A46 Newark Bypass

Scheme Number: TR010065

March 2025

**Statement of Common Ground with
Newark & Nottinghamshire Agricultural Society**

DRAWING TITLE
 Figure 2.4
 Locations of Temporary Works Areas Required During Construction
 Sheet: 1 of 4

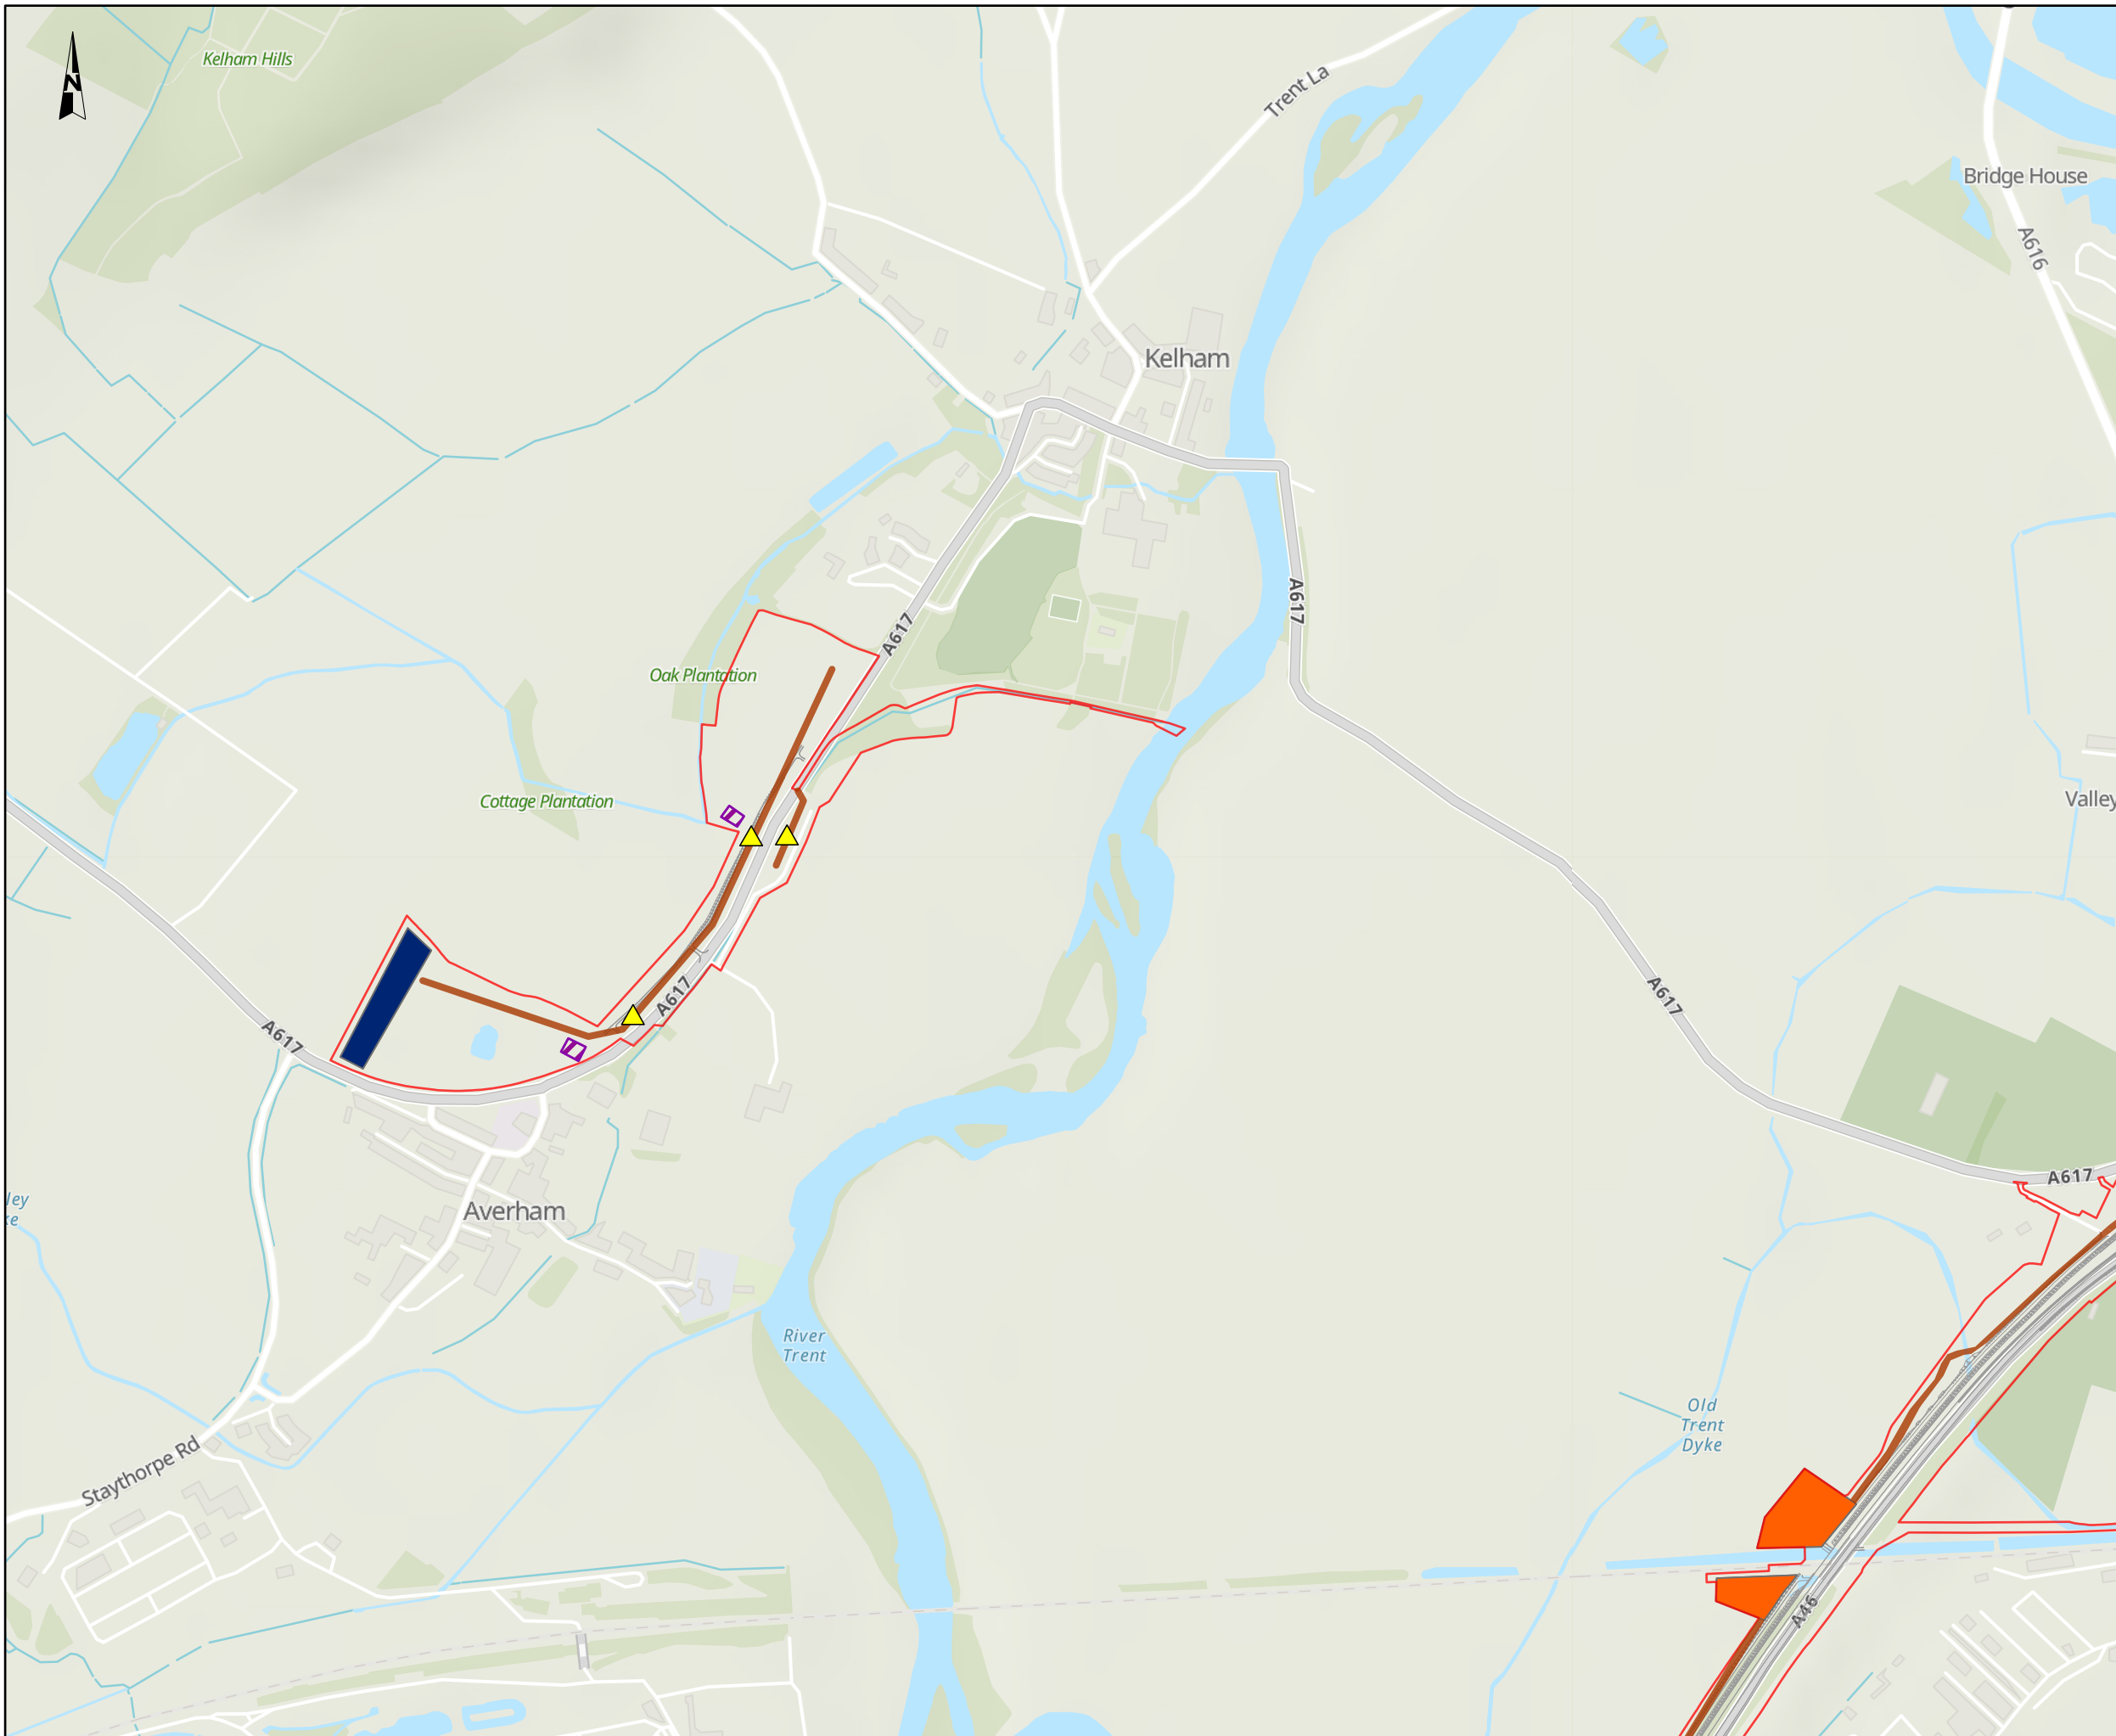
<p>it may not be directly affected by any breach. This matter is of significant concern to the Society.</p> <p>Further NH have not provided clarity on how the Blue Gate access and the driving range access will be maintained and secured. Whilst NH has included some provisions in the OTMP they are not specific and again NH will not enter into an agreement by deed with the Society to include these provisions and therefore ensure the Society can enforce them.</p> <p>In addition the Society requires notification of works to ensure the smooth running of its operations and whilst NH have included some measures in the OTMP they have declined to enter into an agreement with the Society meaning the Society has no ability to enforce any notification provisions.</p> <p>The Society also has concerns about the temporary land take of part of plot 5 /17(d). NH have said it requires this for a compound but have not provided any details as to how existing contracts for these areas can be mitigated.</p>	<p>Statement - Locations of Temporary Works Areas Required During Construction [AS-027] and Sheets 5 and 6 of the General Arrangement Plans [AS-007].</p> <p>Chapter 12 of the Environmental Statement, Population and Human Health [REP5-014] provides an assessment of the impact on the Newark Showground in tables 12-11 (Land take effects during construction), table 12-12 (Access effects during construction), table 12-15 (changes in access to green space, recreation and physical activity) and table 12-18 (Permanent changes in the provision of green space, recreation and physical activity). Paragraph 12.12.4 of Chapter 12 states that regular engagement should be undertaken with the Newark Showground and other recreational activities to ensure that construction activity is planned around key events.</p> <p>This is secured in the Outline Traffic Management Plan [REP6-018] and in the Outline Construction Communication Management Plan in Appendix B.4 of the First Iteration Environmental Management Plan [REP6-012].</p>
